MECKLENBURG COUNTY
Land Use and Environmental Services Agency

April 15, 2008

**Re: Rezoning Petition 2008-084
Approximately 0.42 acres located on the north side of Equipment
Drive between Jeremiah Road and Mineral Springs Road**

SHEET TITLE:
**OVERALL
CONDITIONAL
DEV'T PLAN**

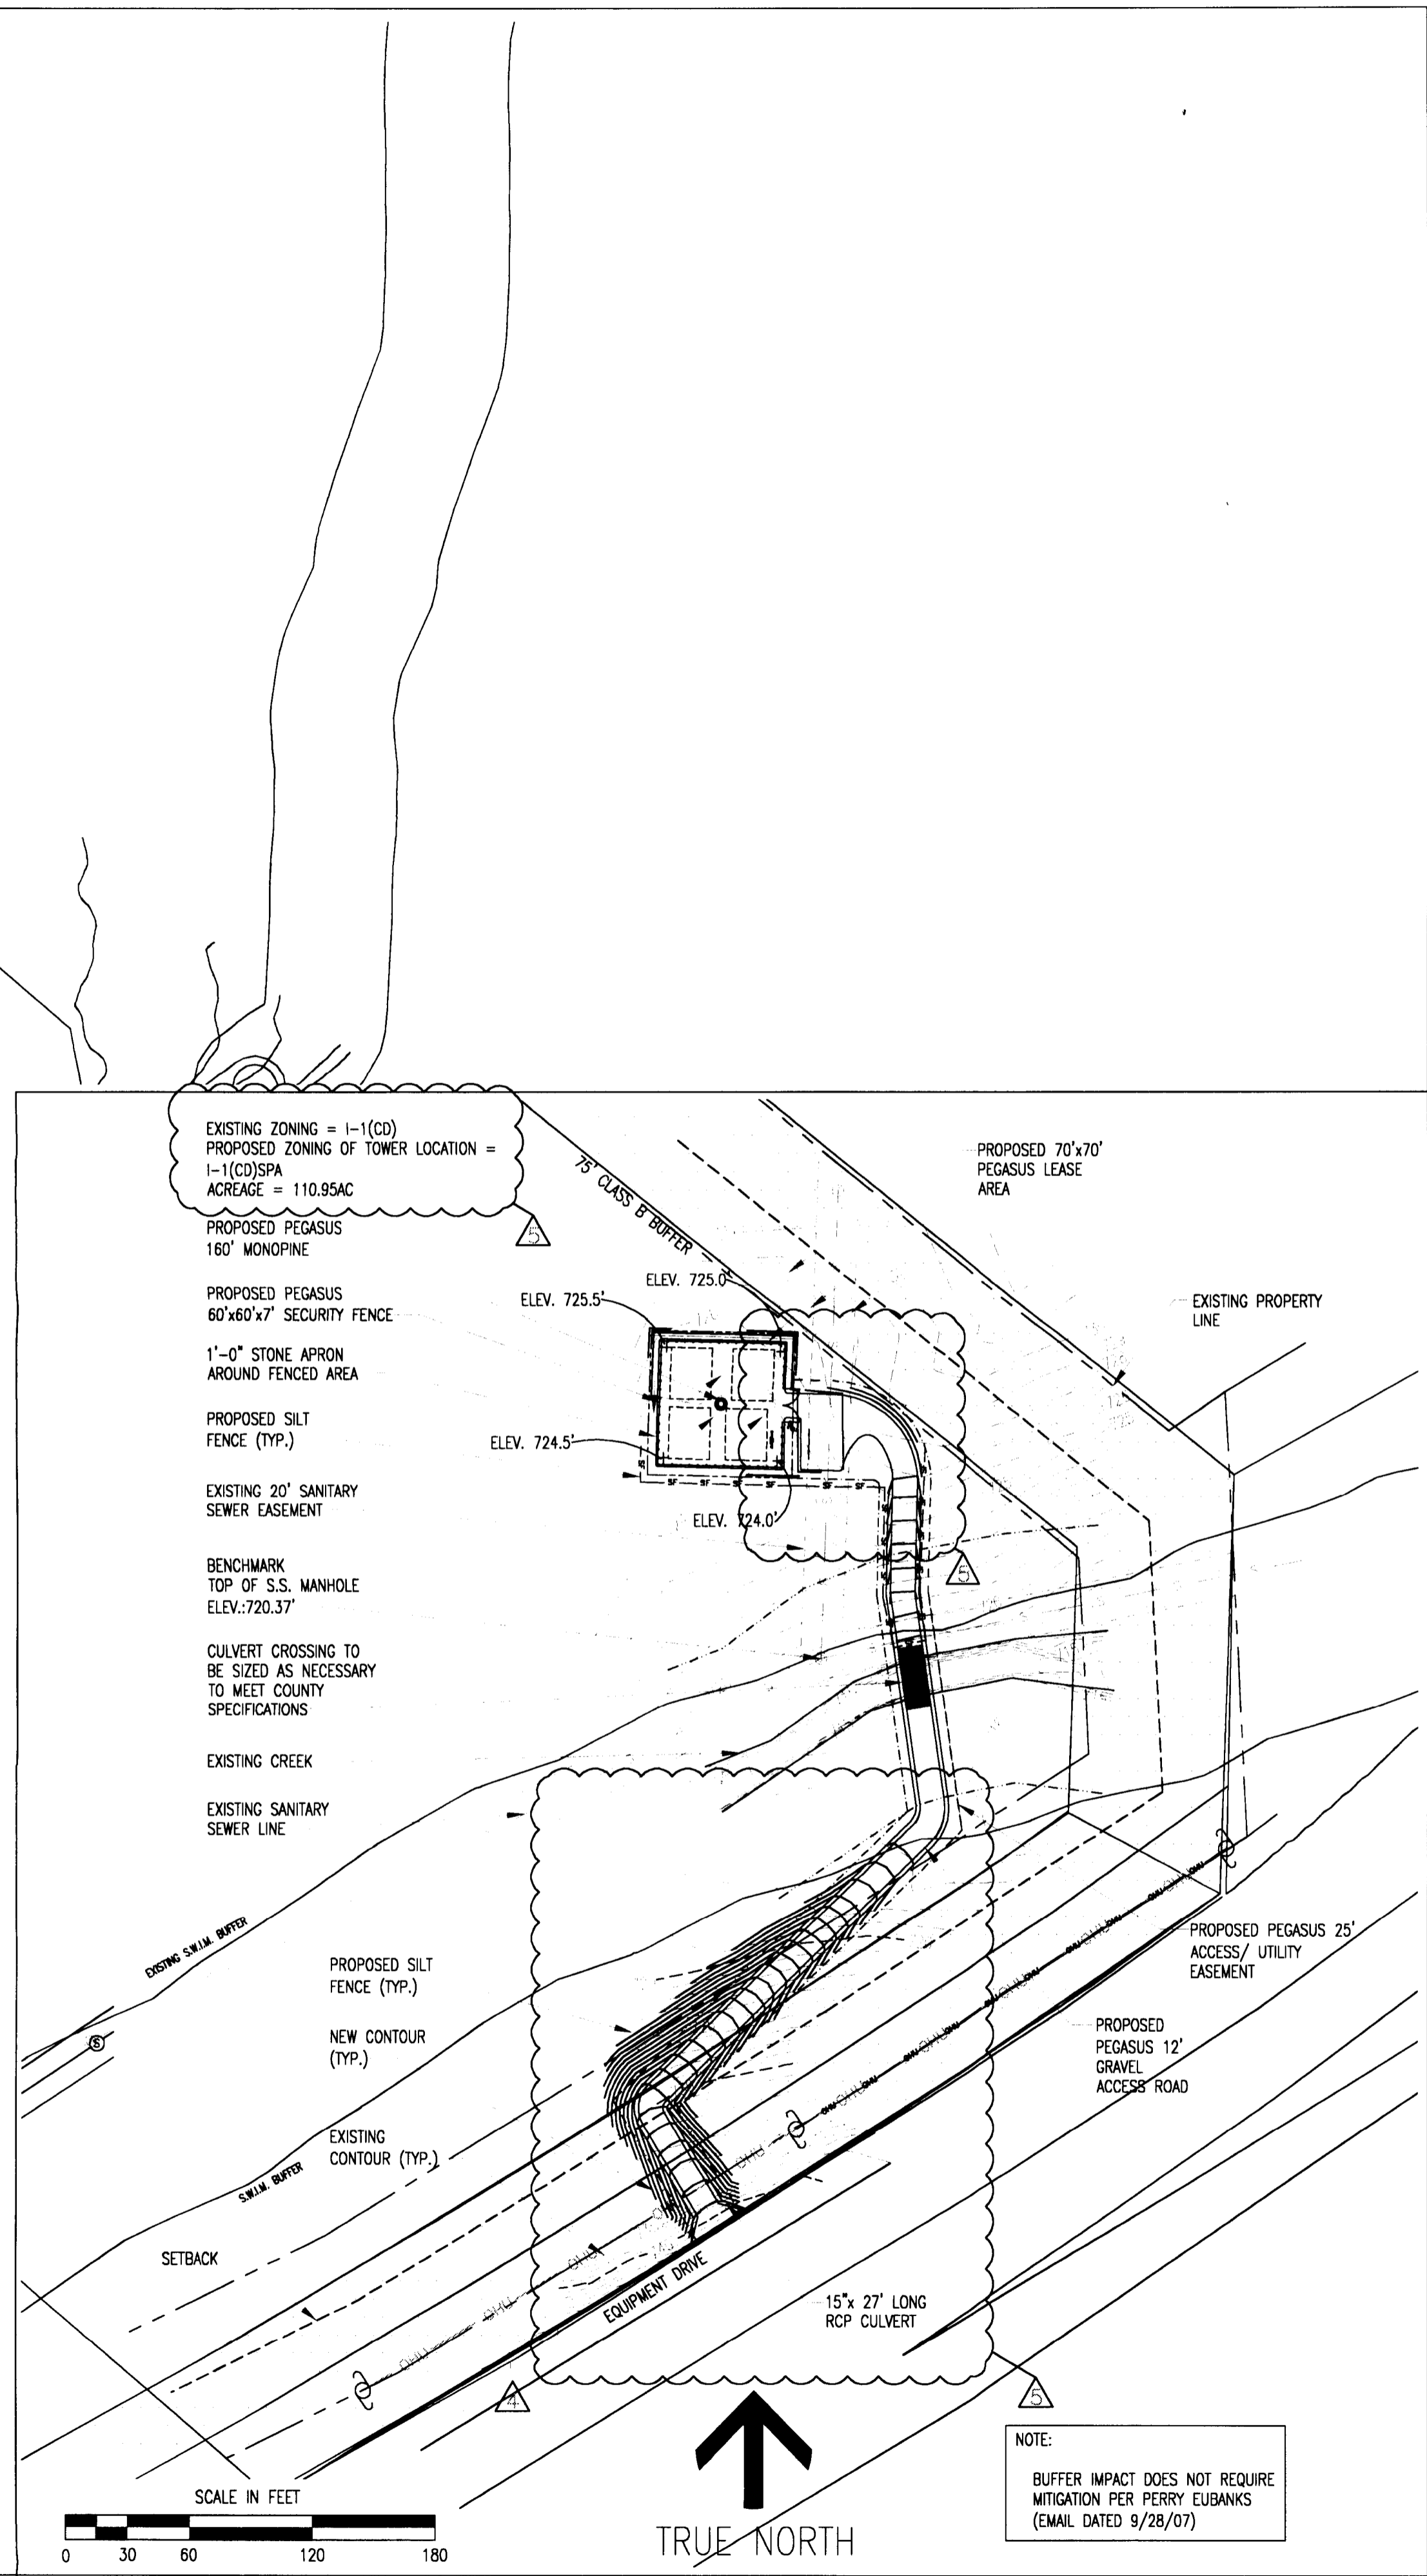
A stream segment located on the subject property drains greater than or equal to 300 acres and less than 640 acres. According to the City of Charlotte Zoning Ordinance, Chapter 12, Part 8- Surface Water Improvement and Management (S.W.I.M.) Stream Buffers, Section 12.804, *Buffer Standards*, streams meeting this criterion are required to have buffers 50 feet in width on both sides of the stream measured from the top of the bank.
